**KIRKLEES METROPOLITAN COUNCIL
INVESTMENT & REGENERATION SERVICE**

DELEGATED DECISION TO DETERMINE PLANNING APPLICATIONS

Reference No:	2025/62/90866/W
Site Address:	26, Hops Drive, Birkby, Huddersfield, HD1 5AD
Description:	Erection of rear dormer and front porch (within a Conservation Area)
Recommending Officer:	Joanna Rednall

DECISION – REFUSED

CLIENT	Asif Ramzan				
ADDRESS	26 Hops Drive Huddersfield, HD1 5DA				
PROJECT	Rear Dormer				
DRAWING	Existing and Prop Layout and Elevations				
DRAWN	UH	DATE	July 24	SCALE	1.50@A1
DWG No.	2443/01A				
STATUS	PLANNING

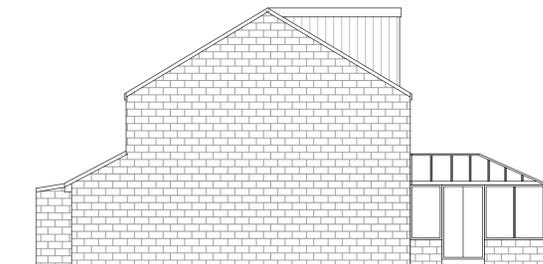
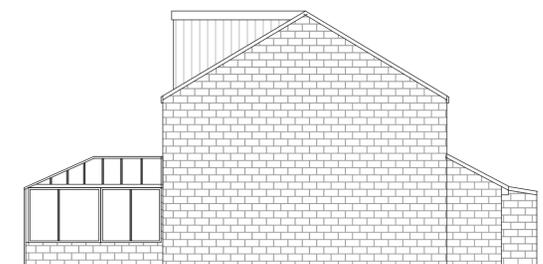
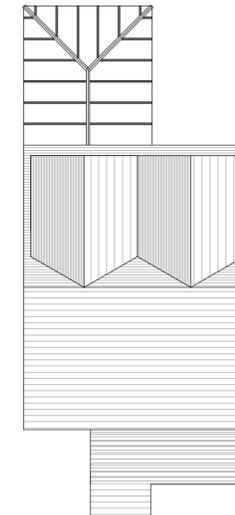
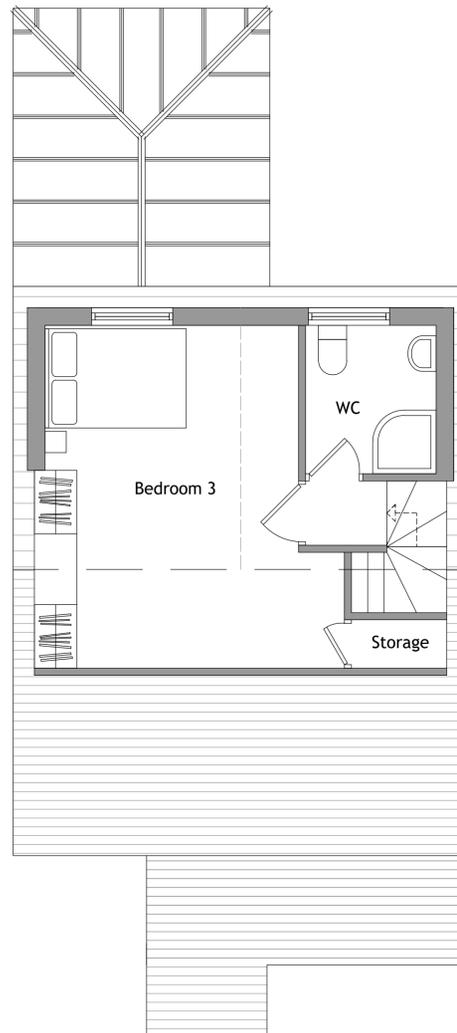
The application seeks permission for the erection of rear dormer and a front extension. The proposed rear dormer is large in scale, designed with a dual pitched roof, and finished in white cladding. It is noted that were the development to be considered acceptable with a differing colour finish a condition controlling its colour finish could be imposed by the LPA.

However, the dormers would occupy a significant proportion of the roof slope and would not be set down from the ridge. As a result, they would constitute a visually dominant and unsympathetic addition that would be at odds with the form and proportions of the host dwelling. Although the dormers are located at the rear of the dwelling, they would still appear as prominent additions and would be visible in certain views from within the Conservation Area, including from Wheathouse Grove.

Furthermore, they would be visible from private viewpoints in neighbouring gardens. While these may not constitute public views, they nonetheless contribute to the way the heritage asset is experienced within its surroundings. This cumulative impact would erode the visual balance of the host property and the wider character of the Conservation Area. Within the immediate area, small, modest front dormers are a characteristic. The proposal would introduce a substantially larger dual-pitched dormer, which is not typical of surrounding roof forms and would appear incongruous when compared with neighbouring properties. This deviation from the prevailing architectural design and form would result in a design that is unsympathetic to the existing built context.

The submitted scheme proposes a shallow mono pitch roof which, by virtue of its limited pitch, would appear almost flat when viewed from the street. This design approach would result in a bulky and visually awkward addition that would appear prominent and incongruous within the wider street scene. Such a form of development would fail to respect the proportions and architectural character of the existing dwelling and would conflict with the established rhythm and uniformity of the surrounding terrace, contrary to the design principles set out within Policies LP24(a) and (c) of the Kirklees Local Plan.

The design of the proposed front extension could be improved through the incorporation of a pitched gable end, which would have more closely reflected the roof form of the host dwelling. The proposed extension would disrupt the symmetry of the principal elevation, which forms a visually prominent façade at the entrance to the housing estate and is widely visible from public vantage points, and from further afar along Blacker Road. The extension would project noticeably forward of the existing single-storey projection. Within the immediate street, the front extension would appear as a non-original and discordant feature. When considered alongside the proposed dormer extensions, the cumulative impact of the works would further erode the architectural integrity of the host property and detract from the character and appearance of the Conservation Area.
